# Rezoning Transportation Analysis

Petition Number: Insert Zoning Petition #2022-005

Revision Log:	Date	Description
	06-23-22	First Review (TM)

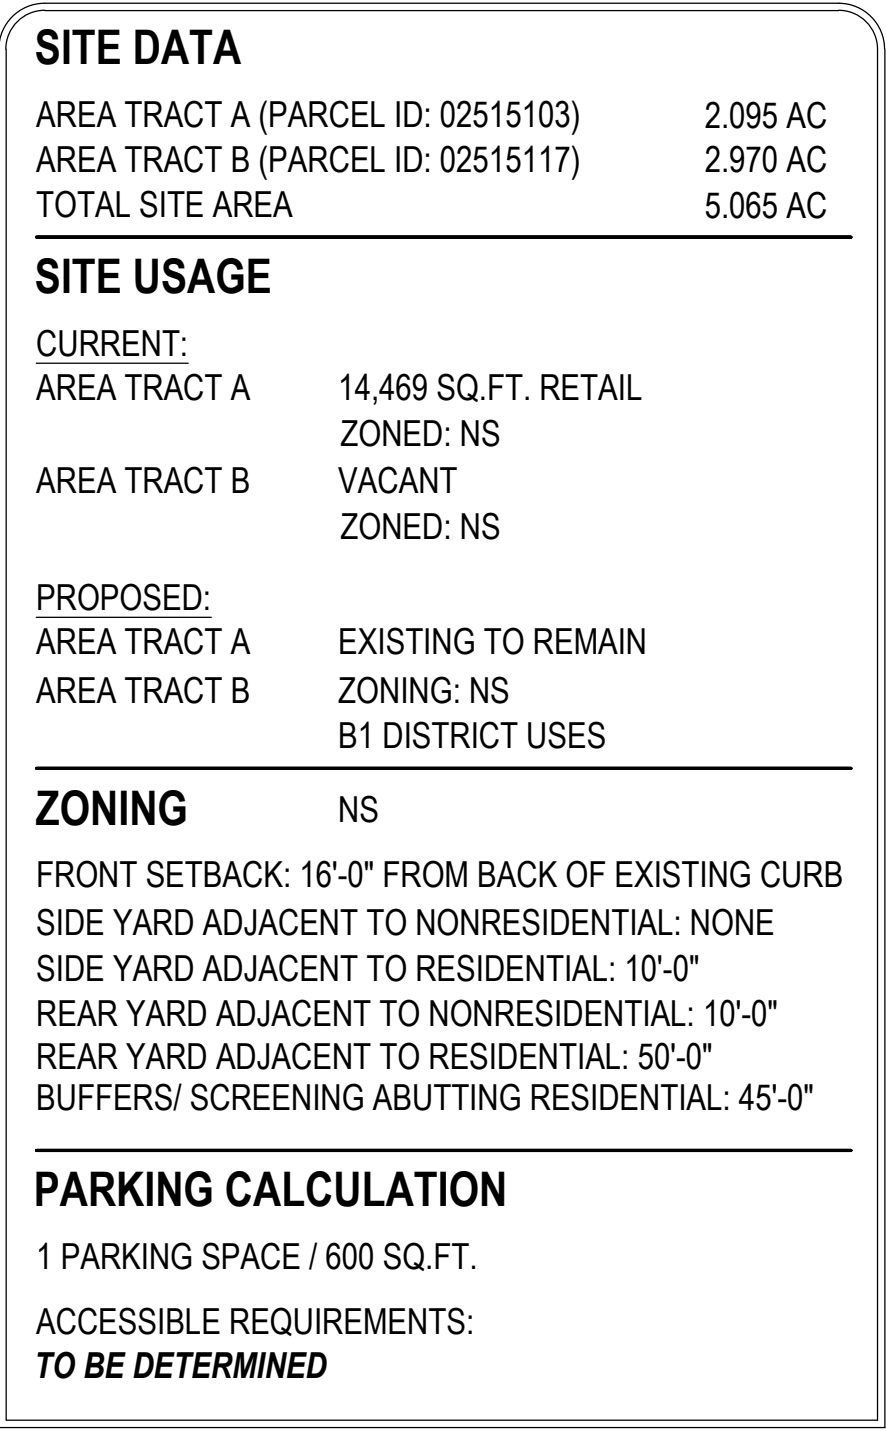
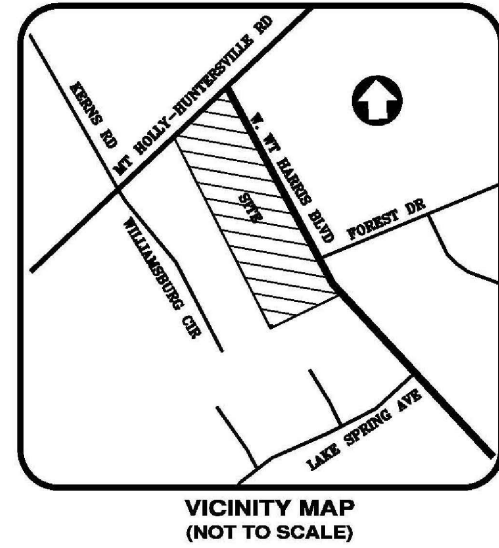
1. **Curbline:** The proposed zoning district has a setback measured from back of the future curbline.
  - a. **W T Harris Boulevard:** Location of curb and gutter is 33' from the centerline of W T Harris Boulevard.

Label and dimension the curb and gutter from the centerline for each road on the site plan.

3. Revise site plan and conditional note(s) to commit to dedicate a minimum of 50-feet of right-of-way from the road centerline. The site plan shall label and dimension the right-of-way from the road centerline. If the proposed multi-use path is located outside of the right-of way provide sidewalk utility easement located 2-feet behind the multi-use path.

4. Per coordination with NCDOT, revise site plan and conditional note(s) to commit to widen WT Harris to provide two southbound through lanes fronting the site that tie into the existing two through lanes just south of project. In leu of widening for an additional through lane, a right turn lane can be installed on WT Harris at the site access.

5. Revise site plan to show access points for each proposed area from the existing access road.
6. Revise site plan to commit to installing 8-foot planting strip and 12-foot multi-use path on WT Harris per Chapter 19. The wider sidewalk also meets the Charlottes Walks Policy and City of Charlotte BIKE Policy.

8. Revise site plan and conditional note(s) to commit to reconstructing the site access driveway to meet standard CLDSM driveway detail 10.25E or 10.28. The site plan shall callout and dimension the driveway at the ROW line.
